**Planning Department
Transportation Development Services**

**Re: Lamar Albuquerque
1600 Airtech Court
Traffic Circulation Layout
Engineer's/Architect's Stamp dated 7-15-15 (M16-D024J1)**

Based upon the information provided in your resubmittal received 7-14-15, the above referenced plan cannot be approved for Building Permit until the following comments are addressed:

No.	Description	Date

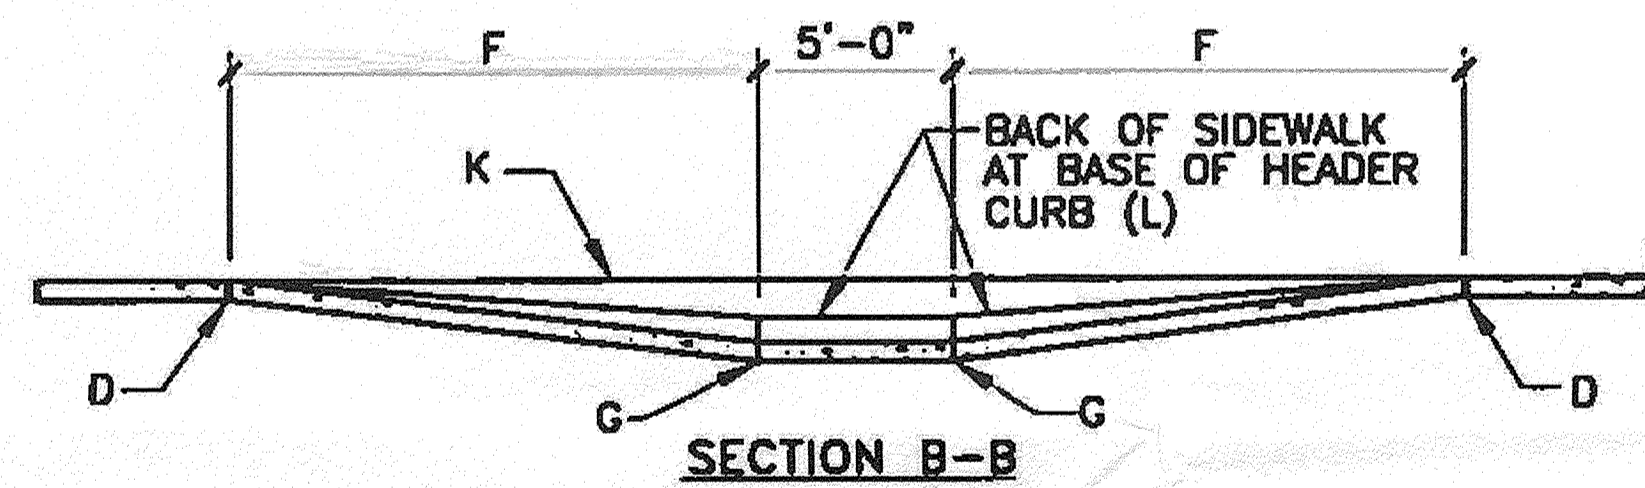
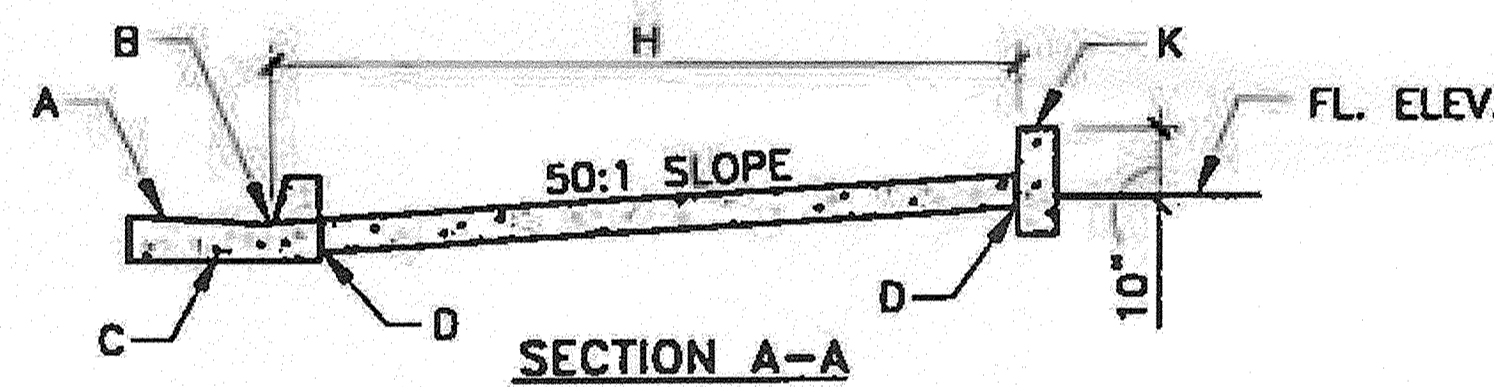
1. Please show a vicinity map showing the location of the development in relation to streets and well known landmarks. Please show a directional arrow.
2. Please show the extent of the project site. Please show the property line, fencing and any other development on the south side of the proposed project site.
3. Per ADA requirements ANSI 502.5, ADA parking spaces must have and unobstructed 8ft. wide by 18 ft. in length. Upon review of the submitted drawings, the wheel stops will be obstructing the total length of the ADA parking spaces.
4. Per DPM, the site must provide bicycle parking space and signage. Per COA Zoning requirements, there must be one bicycle space provided for every twenty automobile or light truck spaces. Please detail location of bicycle parking drawing.
5. Please include two copies of the traffic circulation layout at the next submittal.
